From: [Bryony Stala](#)
To: [Aquind Interconnector](#)
Cc: [Asim Kayani](#)
Subject: West Waterlooville Developments and Grainger Plc written representation and EXQ1 response
Date: 06 October 2020 11:41:56
Attachments: [West Waterlooville Developments and Grainger Plc Written Representations.....pdf](#)

AQUIND CONSULTATION – WEST WATERLOOVILLE DEVELOPMENTS/GRAINGER PLC

On behalf of West Waterlooville Developments and Grainger Plc, this letter provides Written Representations in relation to the land owned by West Waterlooville Developments and Grainger Plc and a response to the Examining Authority's First Written Questions (EXQ1).

TITLE: Order Limits including Onshore Cable Corridor Section 4a
Sheet 4 of 15

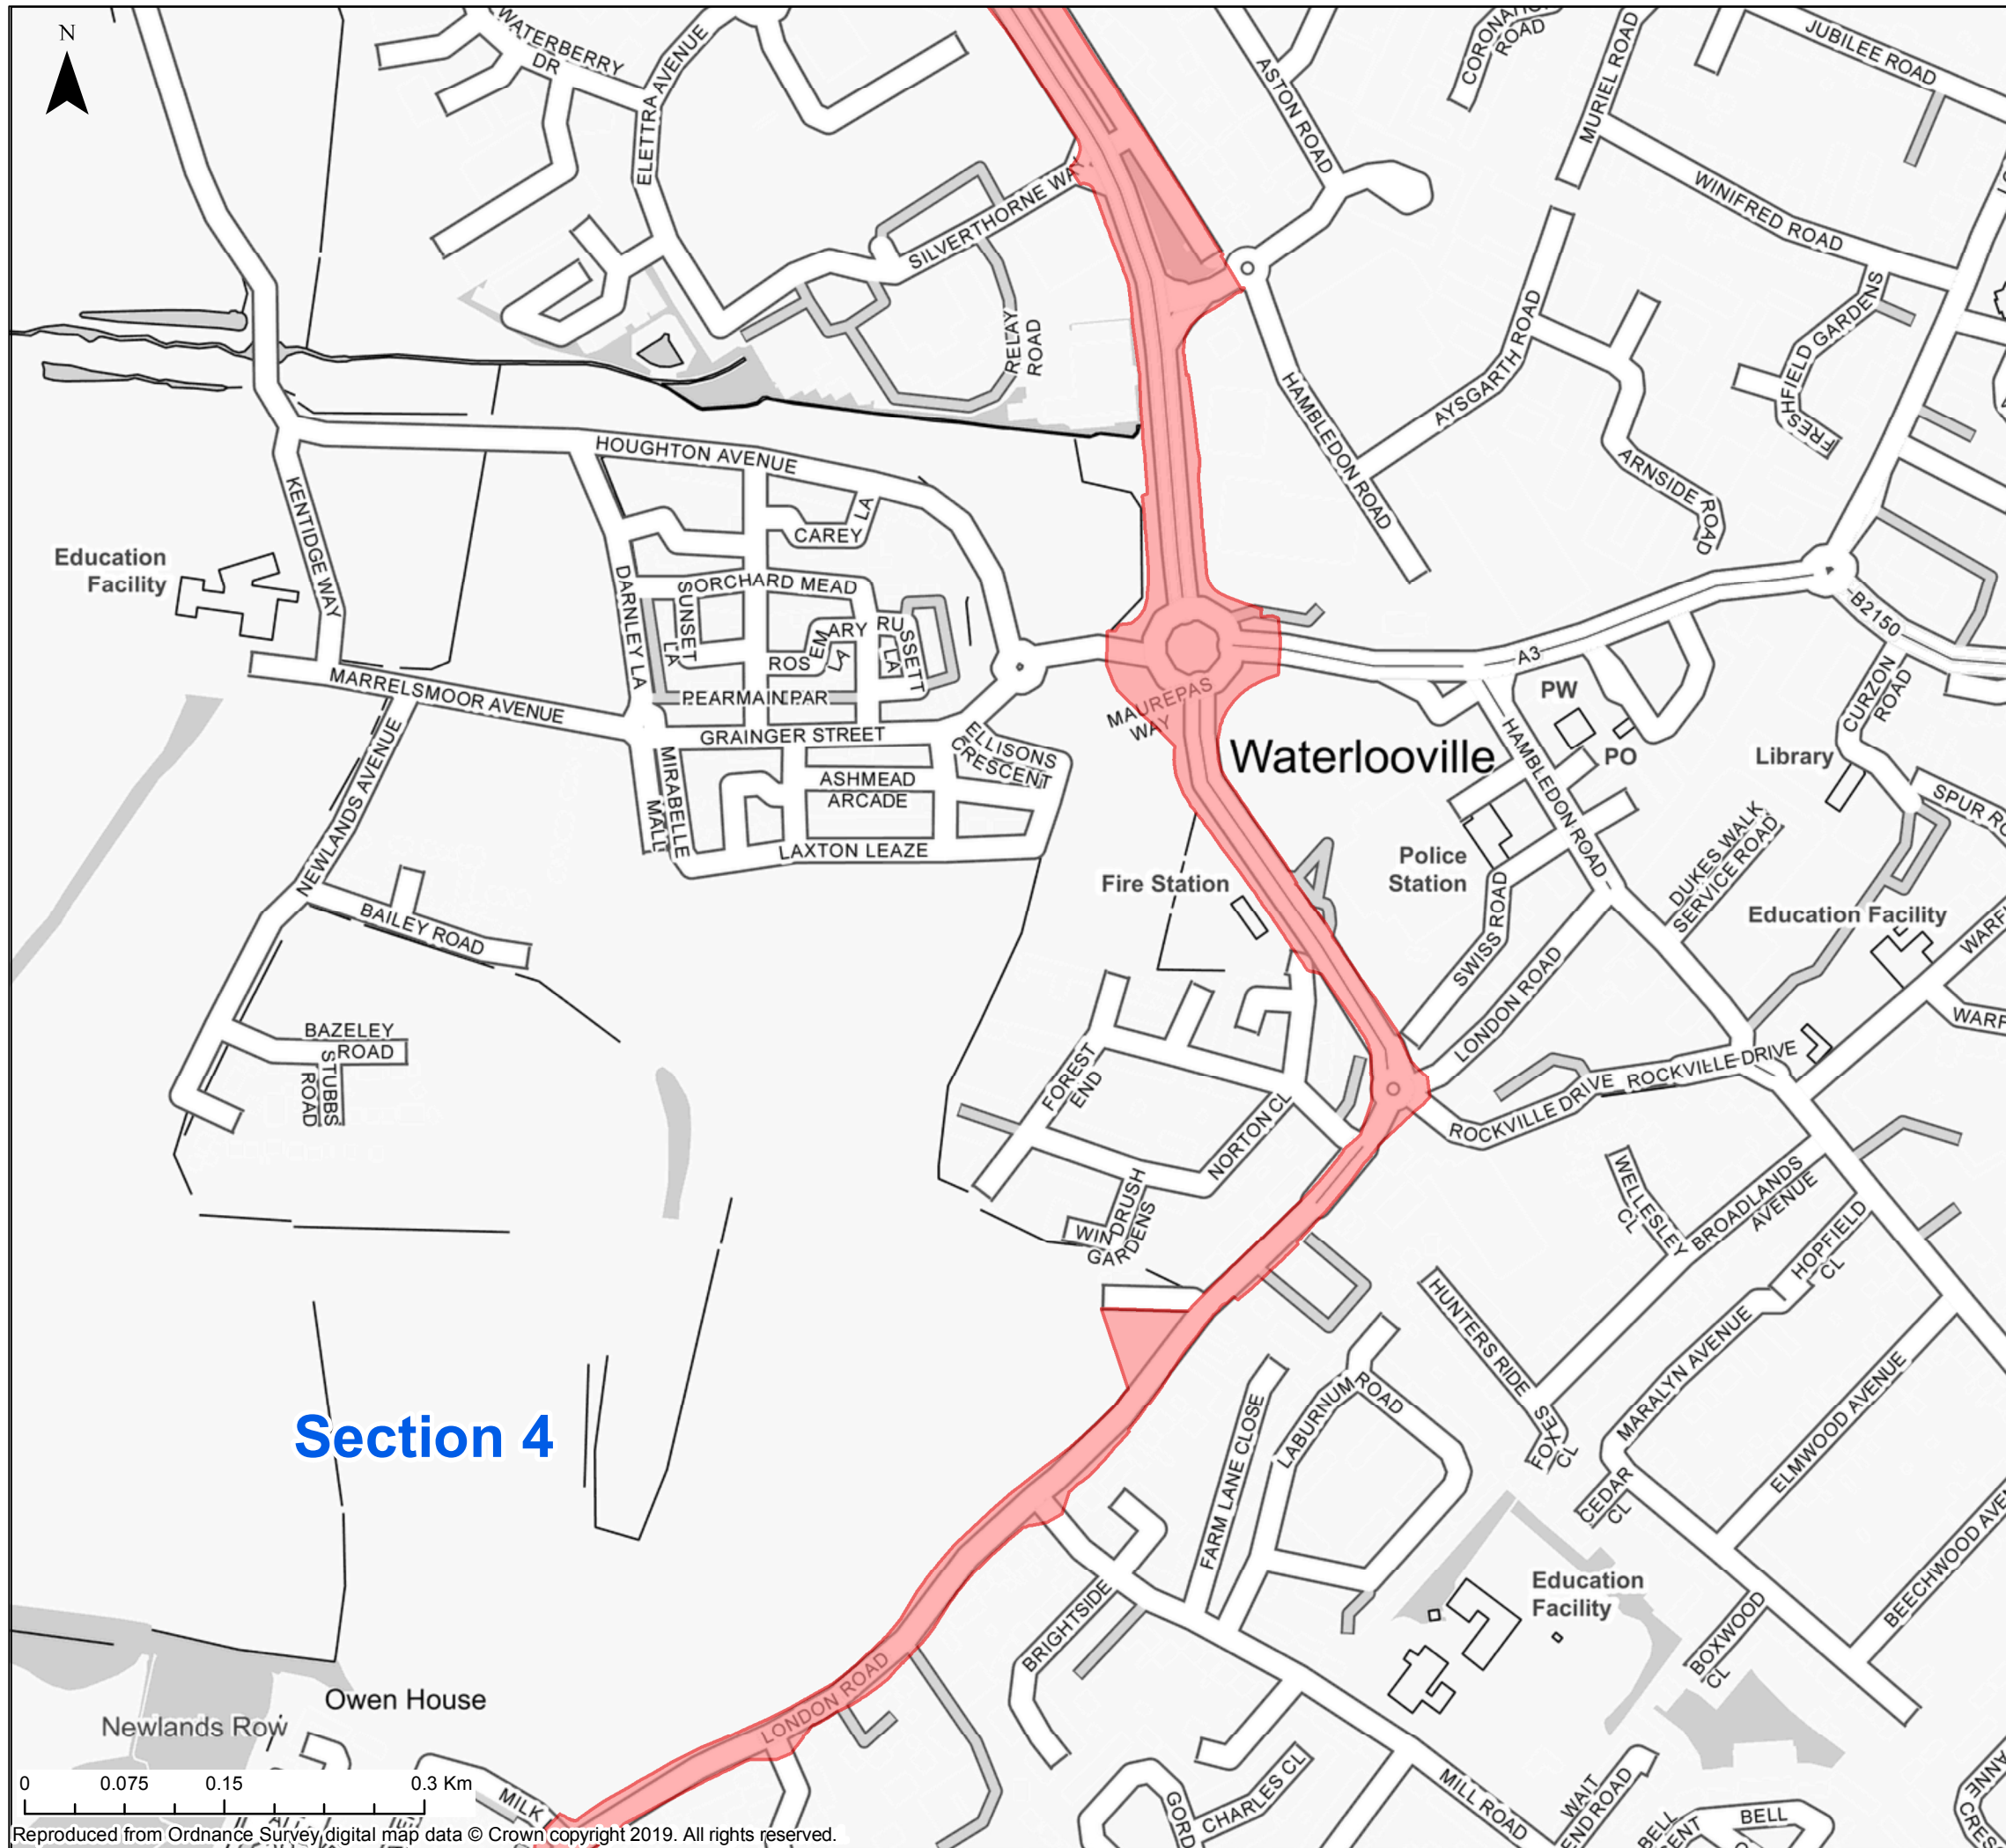
- Application document reference 2.2 Land Plans Sheet 4 of 10 plot 4-1, 4-13, 4-36, 4-38, 4-39 and 4-41
- Application document reference 2.2 Land Plans Sheet 5 of 10 plot 5-12

Having not seen any design work for the interconnector project, there is an outstanding concern about its proximity to future housing and the adverse impact it may have on these dwellings/future residents. West Waterlooville Developments/Grainger Plc therefore requests that all design work is issued for consultation prior to works taking place.

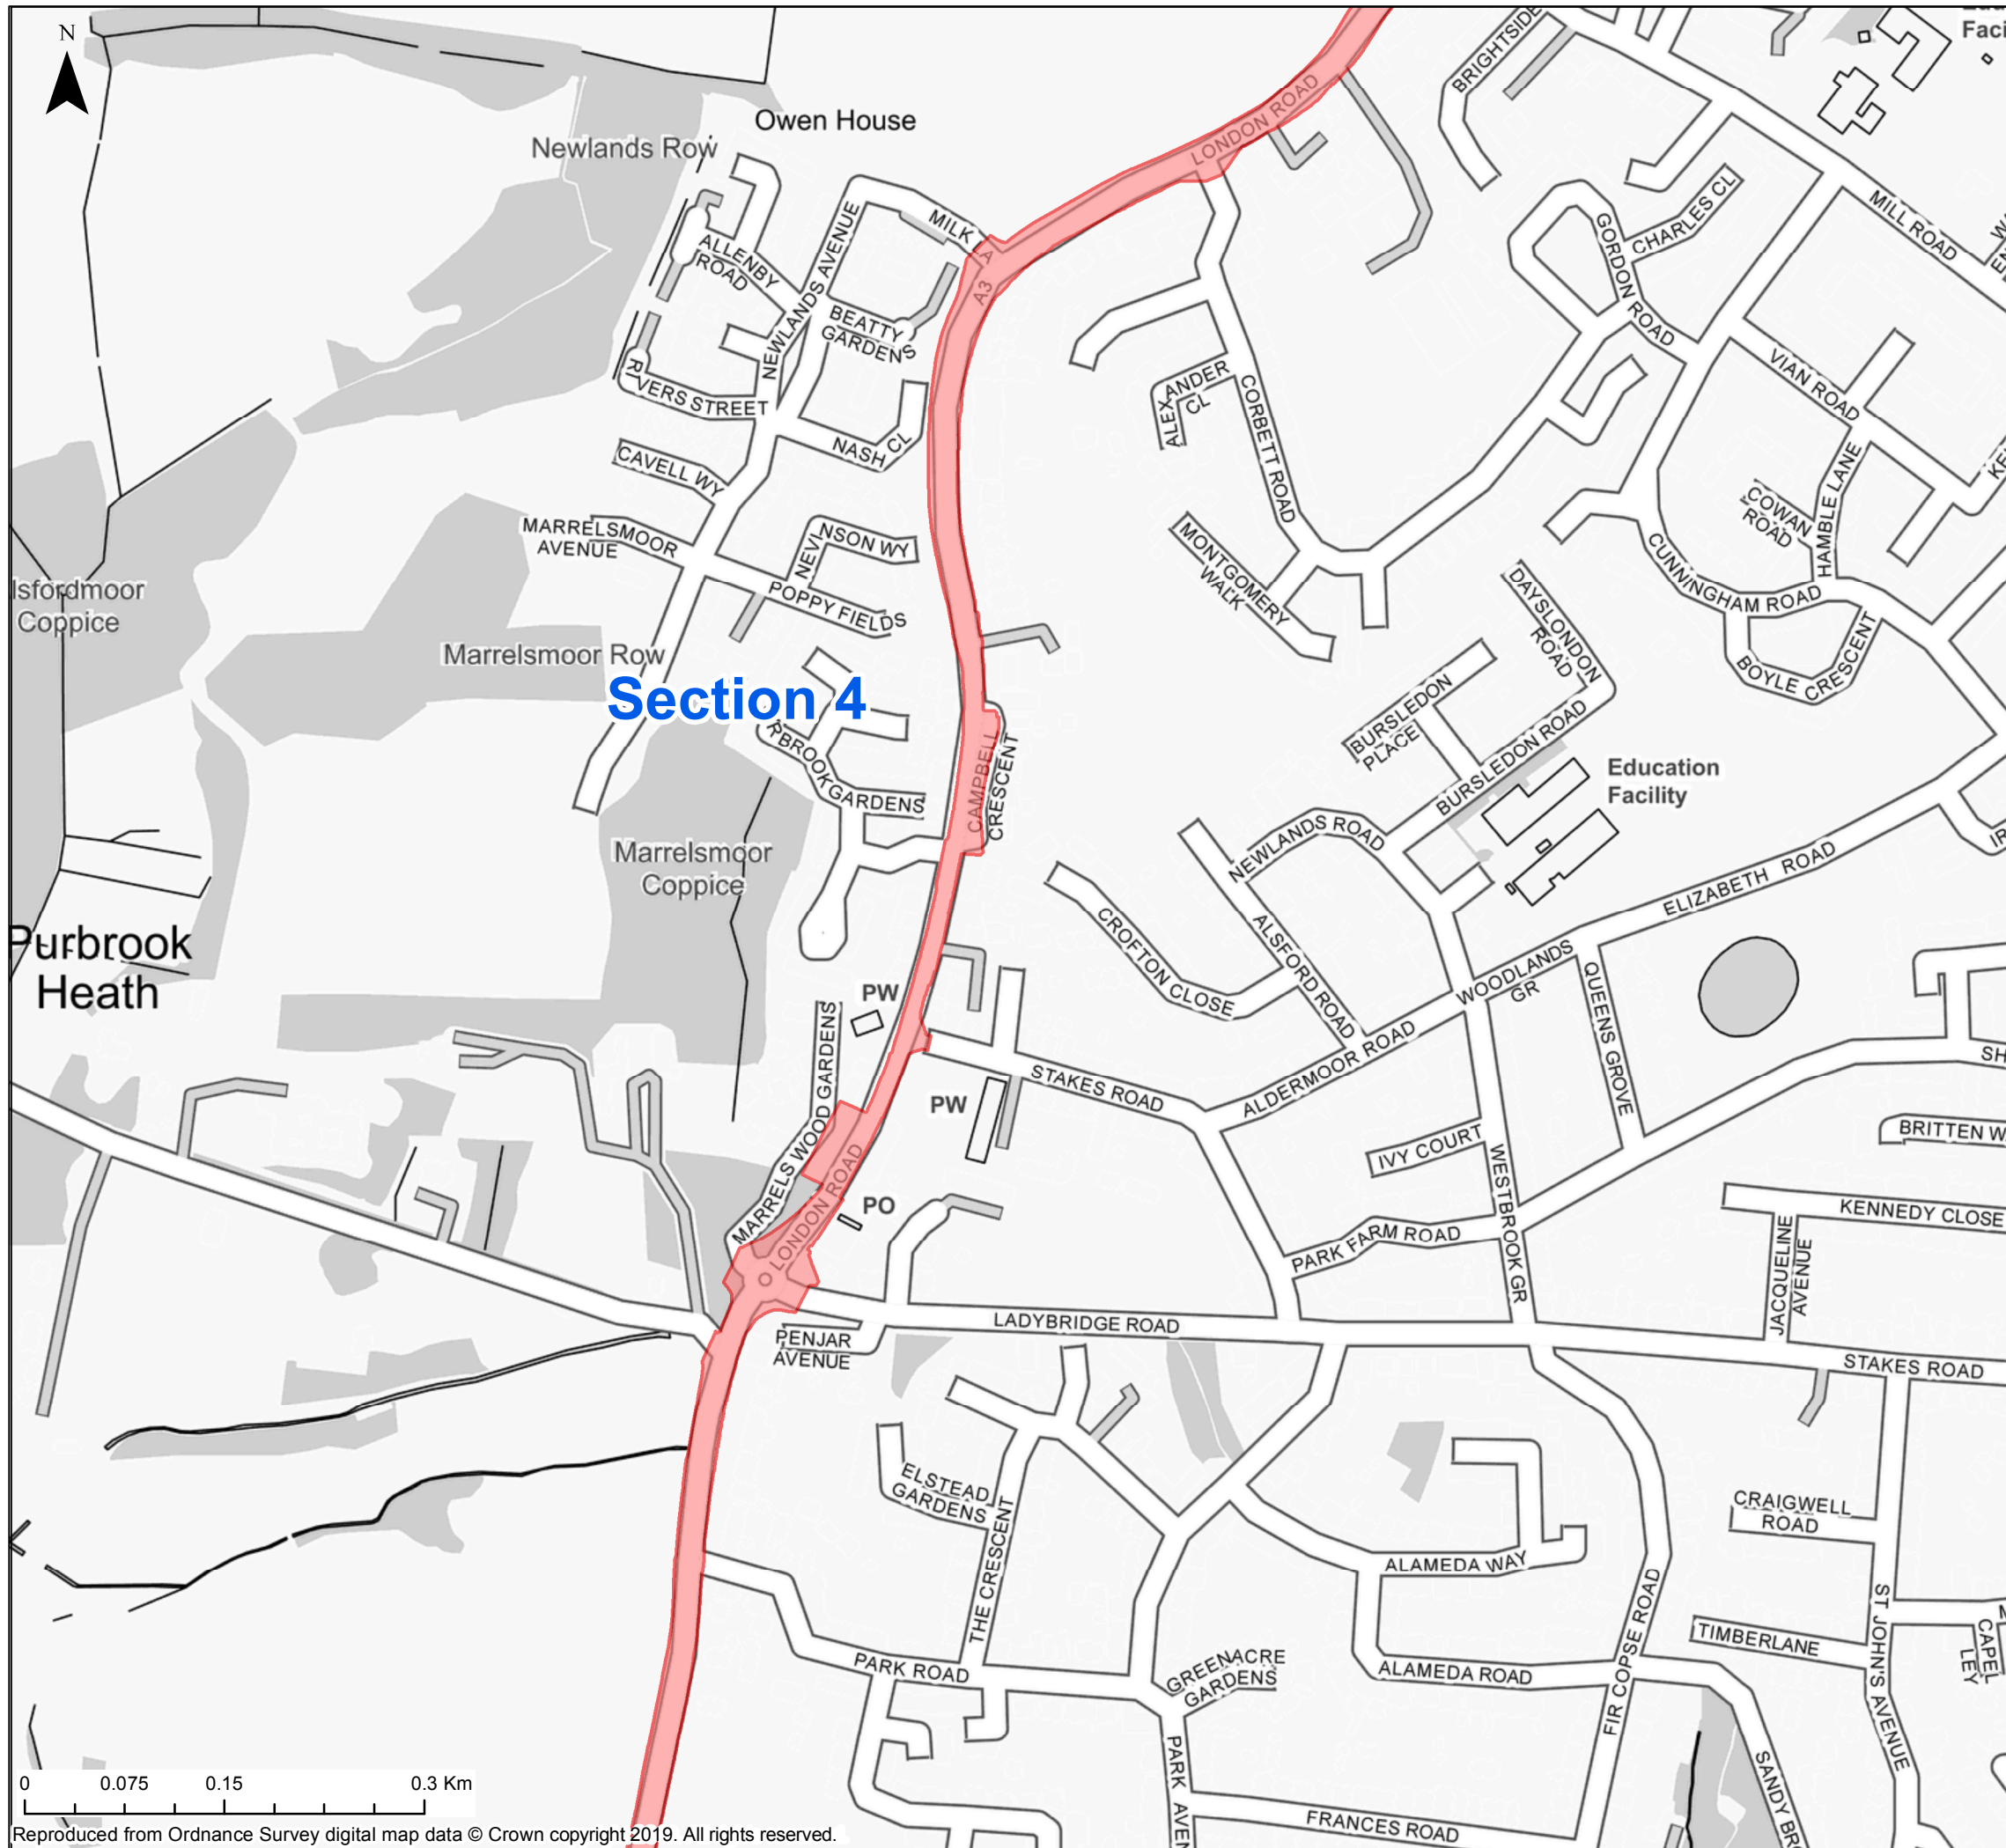
Section 4b of the red line extends over land allocated for the development of the Town Park. Planting and installation of infrastructure associated with the Town Park is currently being installed. The extent of the red line in this location must be reconsidered in order to avoid any impact on delivery of the Town Park.
